## Response to Agency Submissions

Harbourside Shopping Centre Redevelopment

Submitted to Department of Planning, Industry and  
Environment

12 October 2020 | 14657

2 Shadow Projection JUN 1015  
10:15am

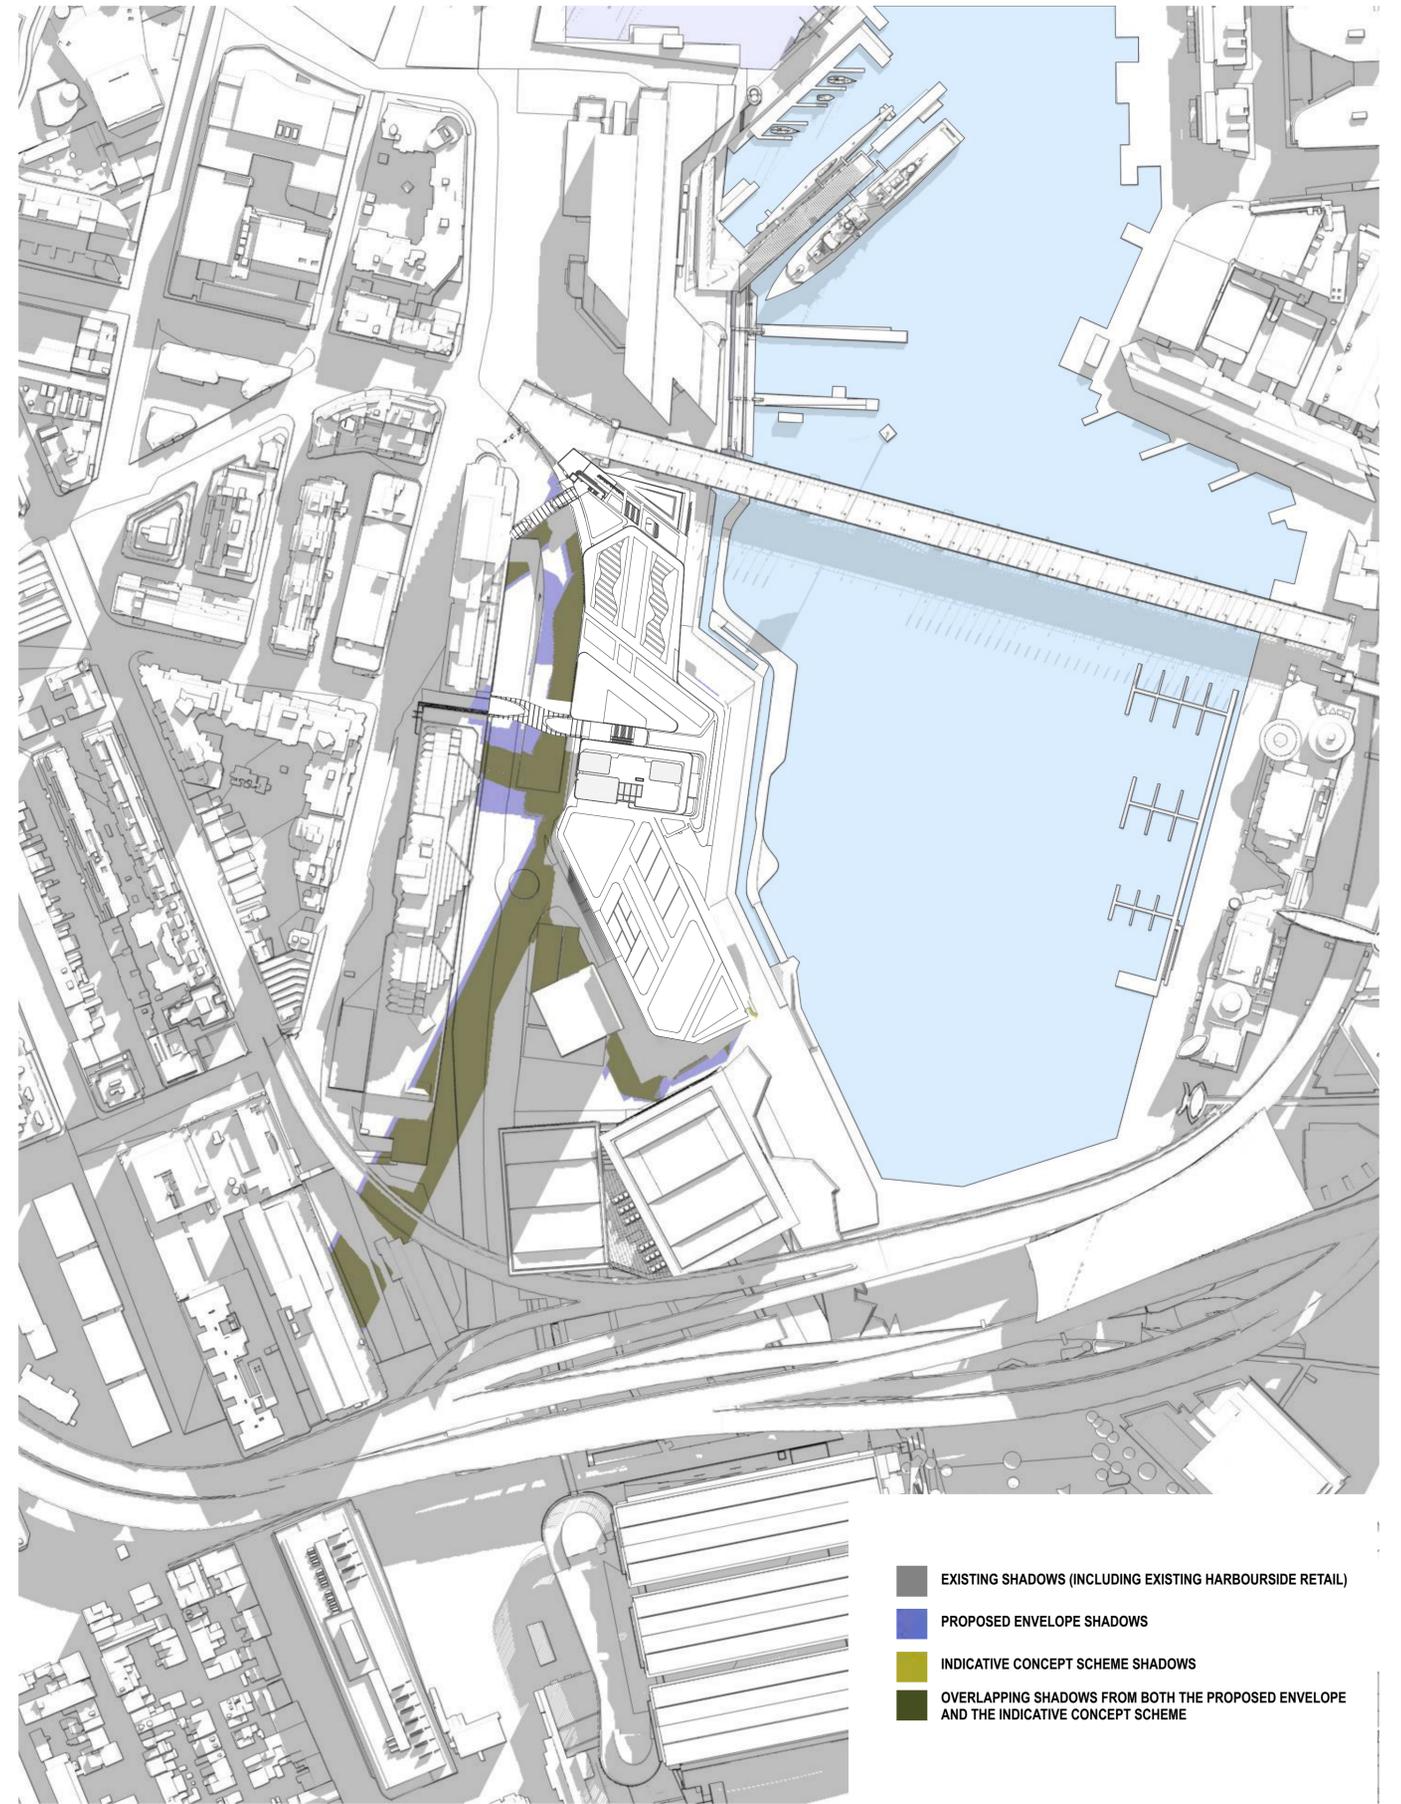
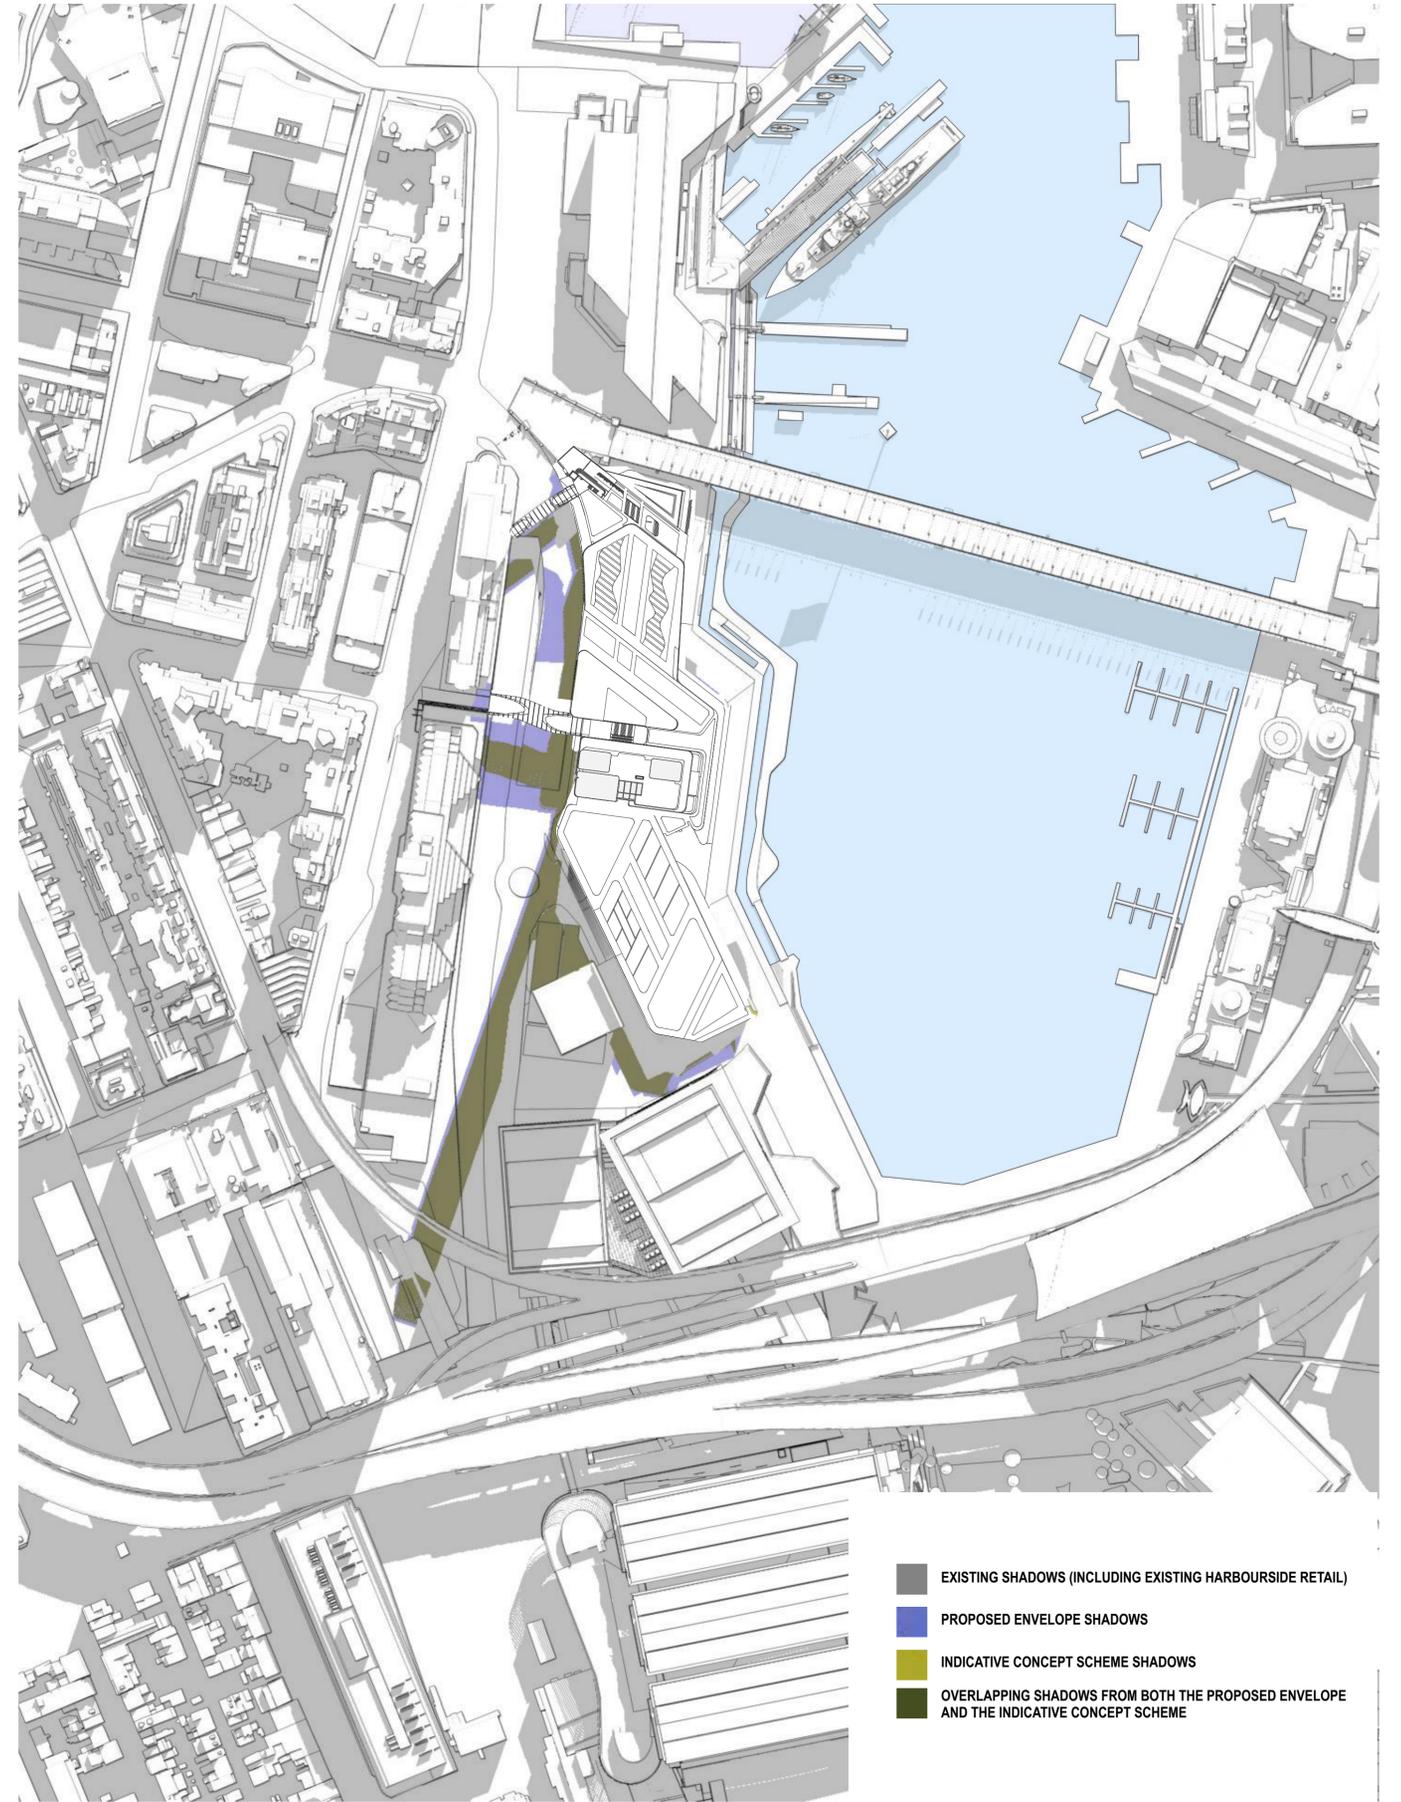
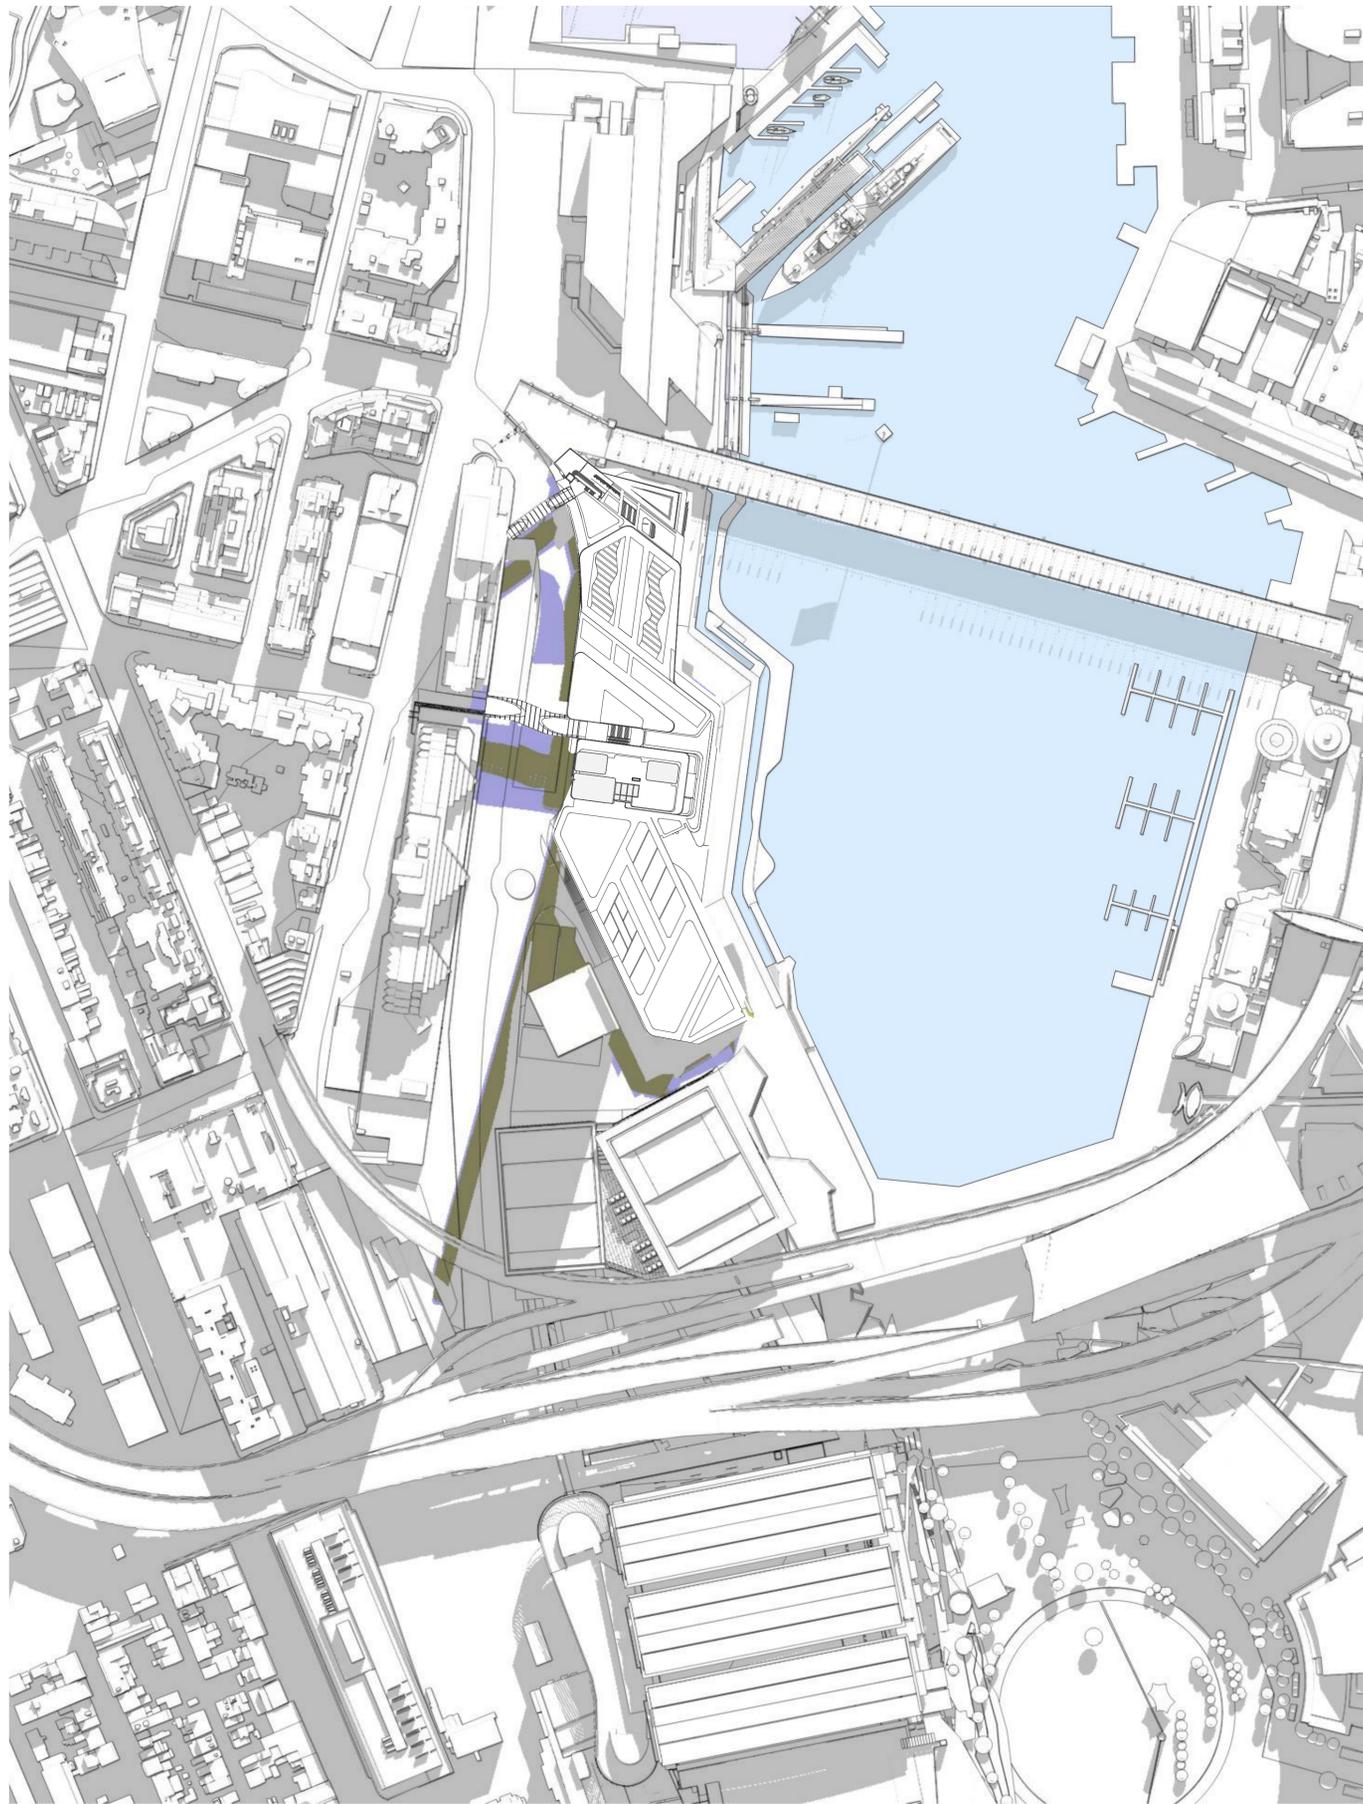
9. Provide a detailed overshadowing analysis of the Darling Harbour foreshore/ promenade in 15-minute intervals.	<ul style="list-style-type: none"> <li>Detailed 15 min interval shadow diagrams have been prepared by fjmt and included within the Architectural Design Report appended to the RTS Report.</li> <li>Refer to RTS Report and Architectural Design Report for detailed discussion and response.</li> </ul>
<u>Private view impacts</u> 10. Provide additional analysis of the view impacts to 50 Murray Street (ONE Darling Harbour) and the Novotel hotel including:  a) identification of levels and units at 50 Murray Street where water view and views to Pyrmont bridge will be affected by the proposal, including additional view analysis assessment against the principles established in <i>Tenacity Consulting v Warringah Council</i> (2004) NSWLEC 140  b) a detailed response to the submission received from ONE Darling Harbour and associated view analysis  c) additional view analysis from Novotel hotel rooms including north-east and east facing rooms at lower, middle and upper levels within the northern and central sections of the building.	<ul style="list-style-type: none"> <li>Refer to RTS Report and updated Visual and View Impact Analysis for detailed discussion and response. Additional view analysis has been undertaken for 50 Murray Street (covering every apartment potentially affected by the proposal) and Novotel as requested.</li> <li>A detailed response to the submissions from One Darling Harbour is also appended to the RTS.</li> </ul>

<p><b>3.5 Overshadowing</b></p> <p>The revised shadow diagrams illustrate that the overshadowing of the foreshore is significant between 12-2pm. Whilst relocating the tower to the centre of site reduces the overshadowing to the foreshore, The City requires updated shadow diagrams at 15-minute intervals to be submitted to determine the degree and percentage of the foreshore promenade affected by the development. This is to ensure that the public realm receives solar access at the highly sought lunchtime hours.</p>	<ul style="list-style-type: none"> <li>• Detailed 15 min interval shadow diagrams have been prepared by fjmt and included within the Architectural Design Report appended to the RTS Report.</li> <li>• Under the proposed development, the public domain located to the east and south of the site and more broadly within Darling Harbour will continue to be provided with direct sunlight throughout the morning period on June 21 (the winter solstice) before shadow resulting from the proposed envelope occurs after midday.</li> <li>• It is noted that there are still vast areas of accessible sunlight available in the Darling Harbour public domain notwithstanding the proposed development, including during the key lunchtime period of 12:00pm to 1:00pm when the general public is most likely to use and appreciate the space.</li> <li>• Overshadowing of the waterfront promenade during the afternoon period on the winter solstice would be expected with any reasonable built form outcome on the site, given the proximity of the promenade on the eastern side of the building form. The proposal also offsets additional overshadowing to the public domain, including through the creation of a new northern Guardian Square (1,500sqm) that will have solar access across the entire day for all periods of the year.</li> <li>• The overshadowing expected to result from the tower envelope is restricted to a small proportion of the overall Darling Harbour public domain and is limited to the western and southern side of the public domain. A significant area of waterfront public domain within and surrounding the site is still within direct sunlight between 1:00pm and 3:00pm on the winter solstice.</li> </ul>
